Australian Turf Club Royal Randwick Racecourse-Hotel Response to Submissions

Prepared for the Australian Turf Club • November 2012

The application number for this project is SSD 5002 – 2011 and the applicant is the Australian Turf Club (ATC).

Figure 05 – Proposed Right Hand Turn/Access Arrangement

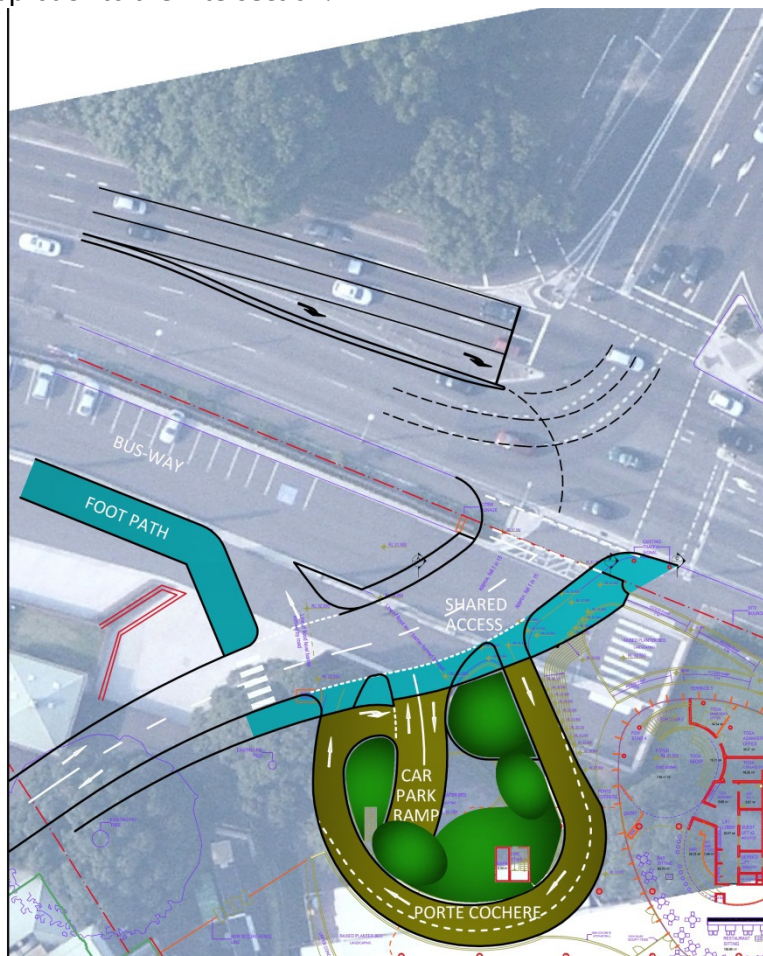
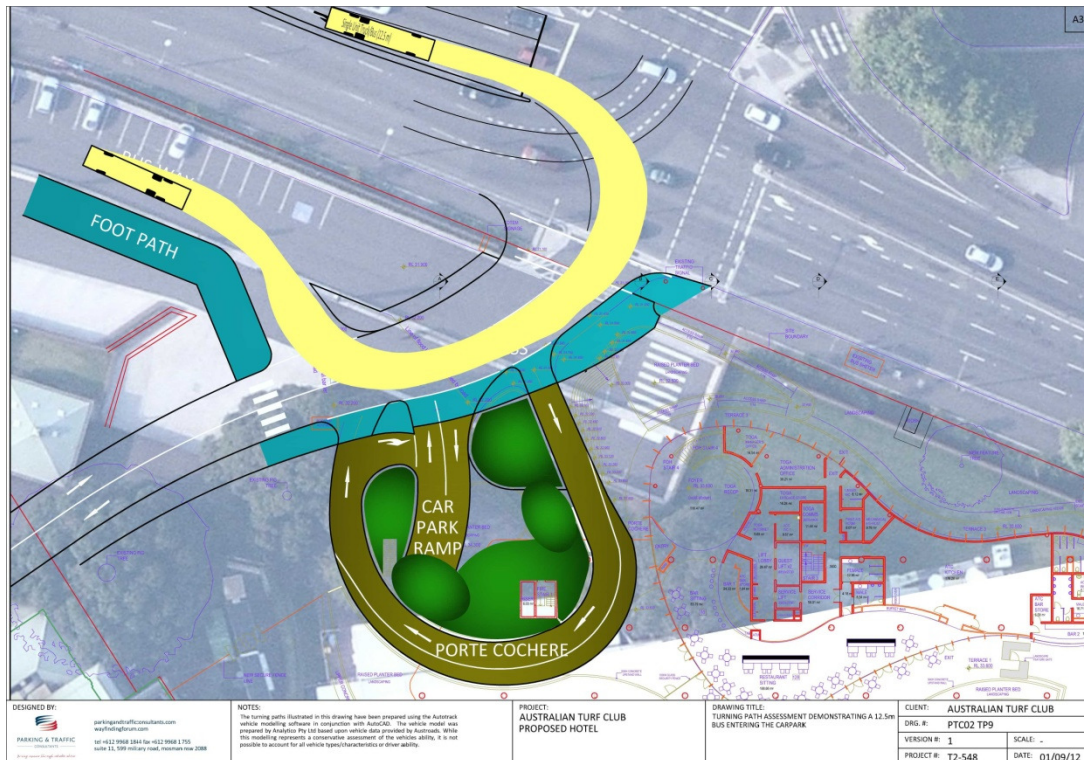
REQUIREMENT	RESPONSE
TRAFFIC AND PARKING	
the proposed right turn into the site from Alison Road is not supported due to potential negative impacts on the surrounding road network and bus operations. An alternate arrangement should be considered to accommodate expected additional traffic without impacting on the existing road network. Any proposed alternate access arrangement should be supported by details of any SIDRA Modelling used, scaled plans illustrating adequate lane widths and vehicle turning circles into the site.	Refer to 6.5
the proposed use of the Racecourse accessway by taxis and private vehicles, exiting the hotel, conflicts with the intention of the Racecourse accessway to provide clear and unobstructed access for buses.	Refer to 6.5
the proposed location of the driveways, Porte Cochere and their proximity to the Alison Road intersection should be reviewed to establish whether a more efficient arrangement could be provided, which would reduce the likelihood of accidents and/or vehicle queuing which could impact upon the surrounding road network.	Refer to 6.5
